Rezoning Transportation Analysis
Petition Number: Insert Zoning Petition #2021-214
General Location Identifier: 11123345

Date	Description
01-21-2022	First Review (AO)
02-24-2022	Second Review (AO)

RZ - 102
 © STIMMEL ASSOCIATES, P.A.

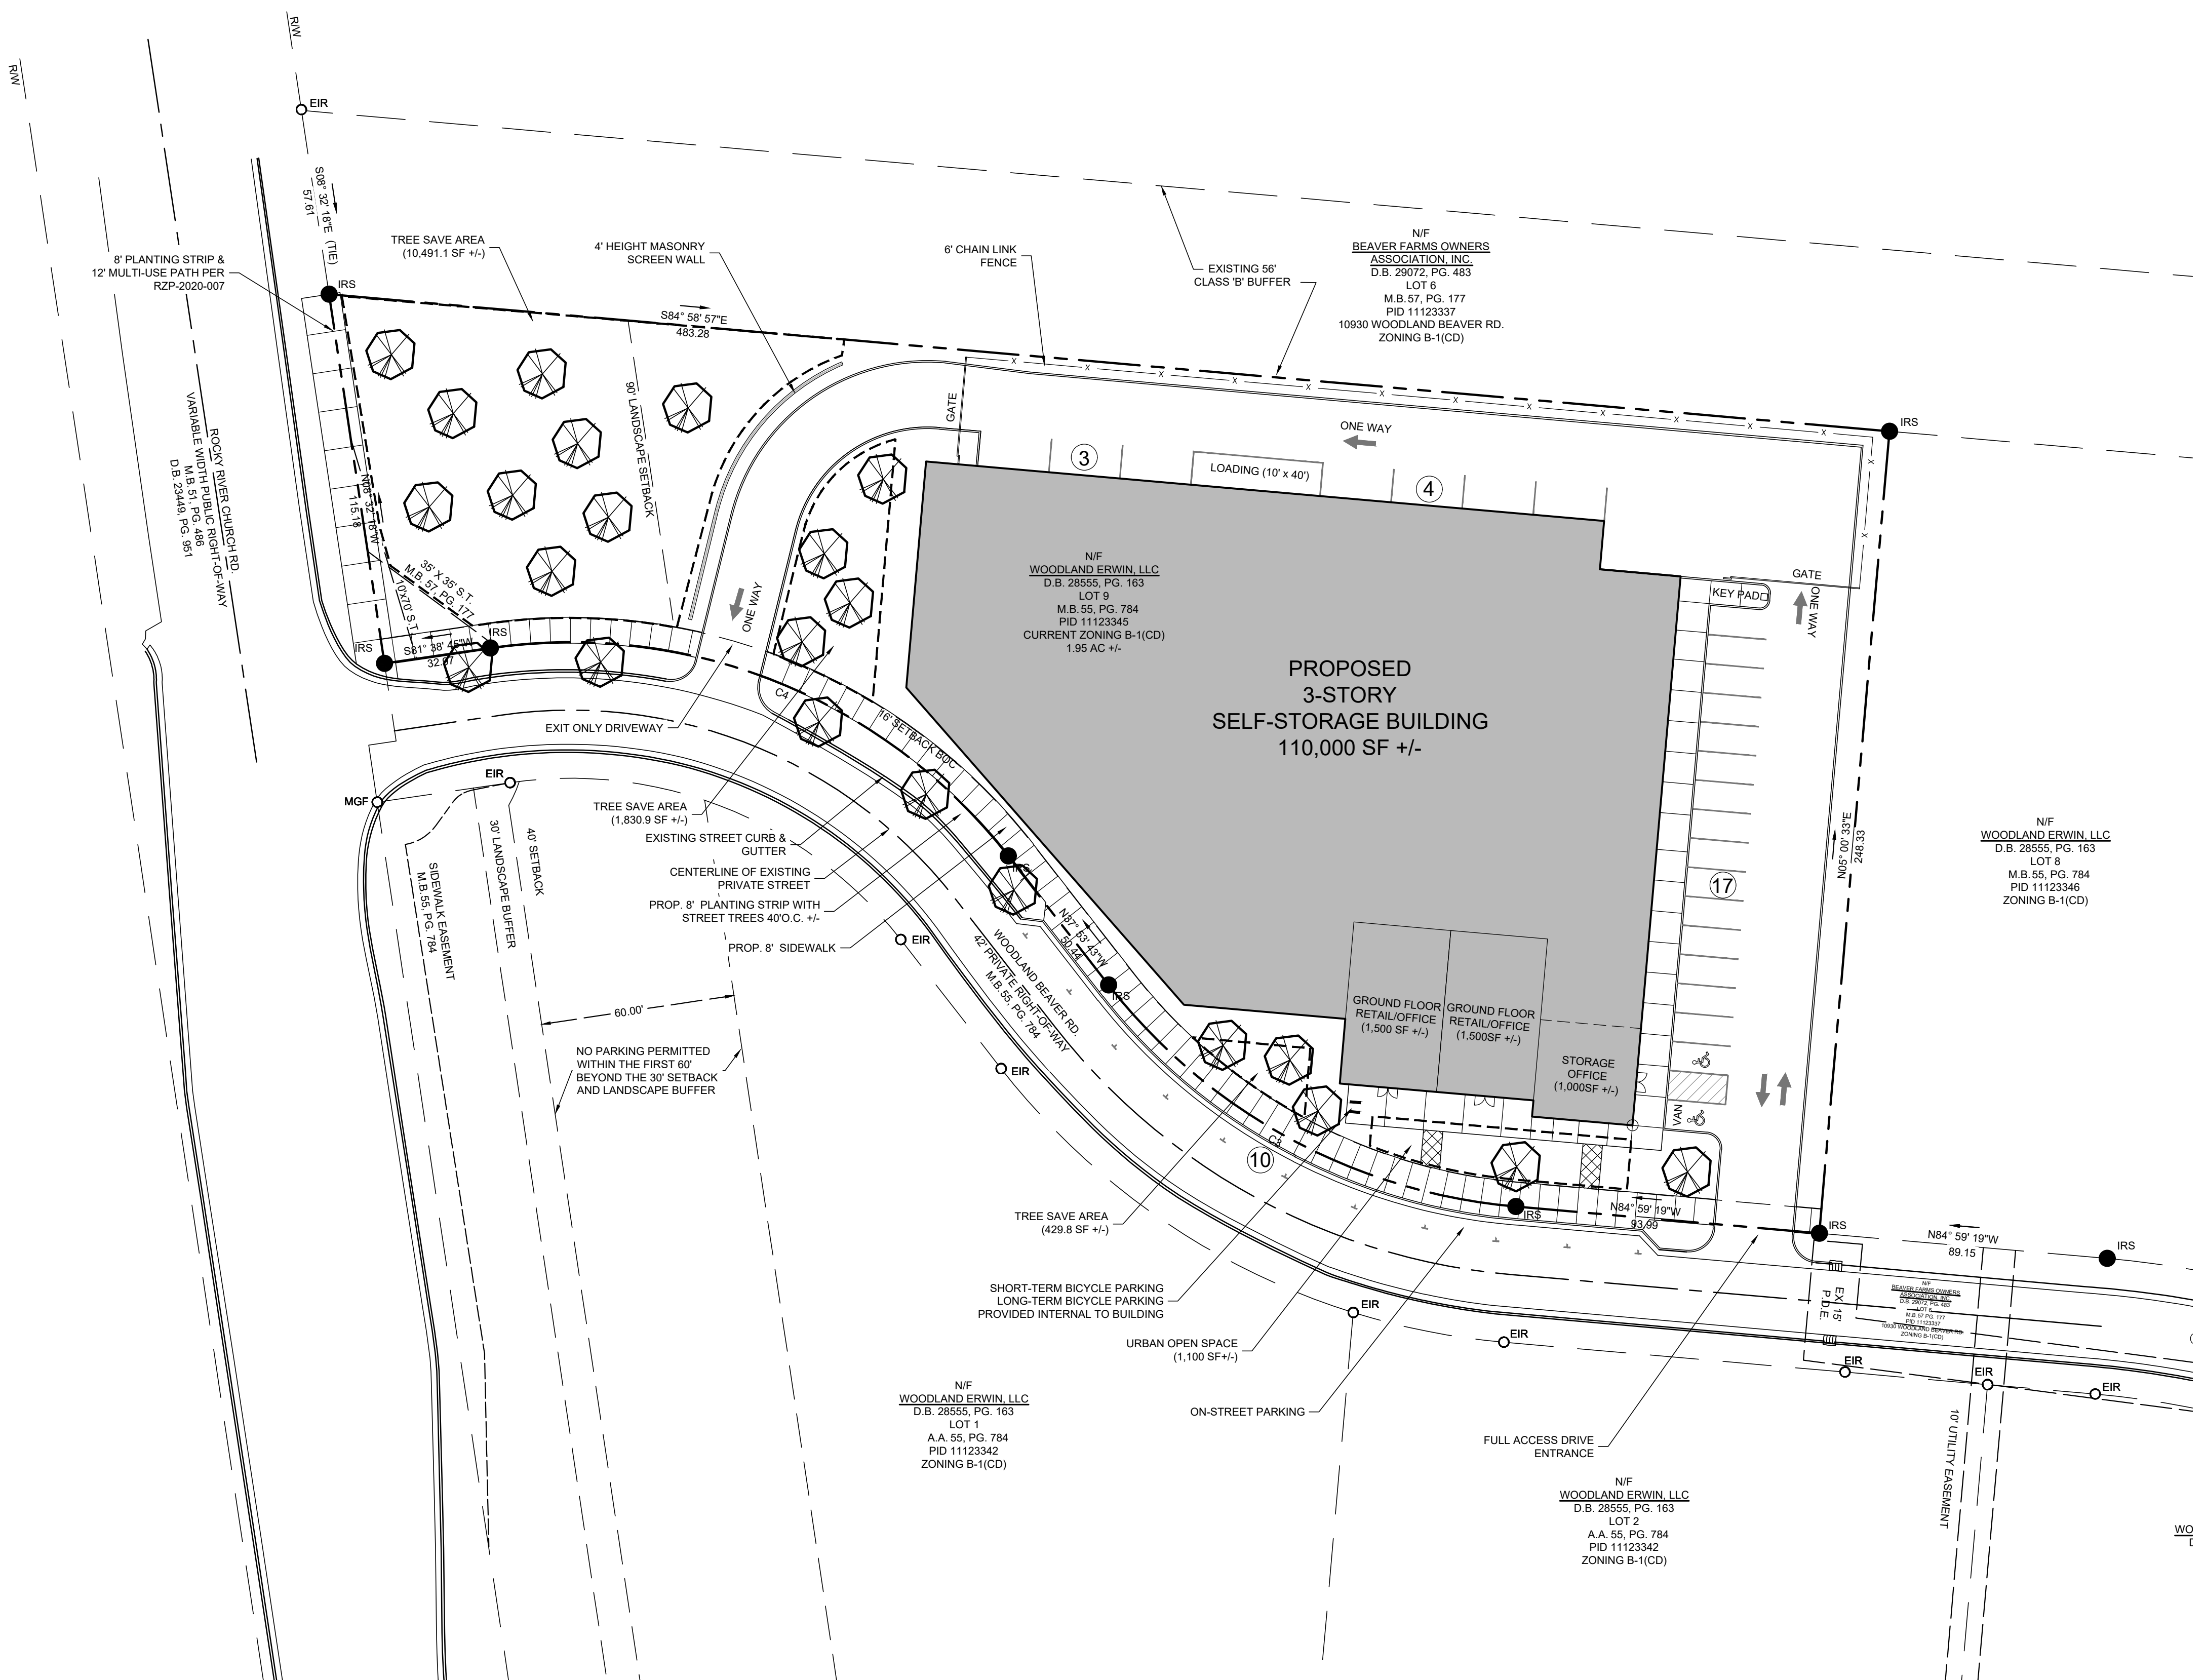
Label and dimension the curb and gutter from the centerline for each road on the site plan.

The site plan shall label and dimension both items from the back of curb and gutter and road centerline.

Label and dimension from right of way line along Rocky River Church Road.

3. ~~**Resolved (New Site Plan, 2-14-22):** Revise site plan to commit to construct an 8-foot planting strip, 12-foot multi-use path along Rocky River Road and an 8-foot planting strip and 8-foot sidewalk on Woodland Beaver Road. Site plan shows call out show multi-use path along Woodland Beaver Road.~~

4. ~~Resolved (New Site Plan, 2-14-22):~~ Revise site plan and conditional notes showing a minimum of 100' of separation from proposed egress access point of Woodland Beaver Road measured from right of way line from Rocky River Church Road.
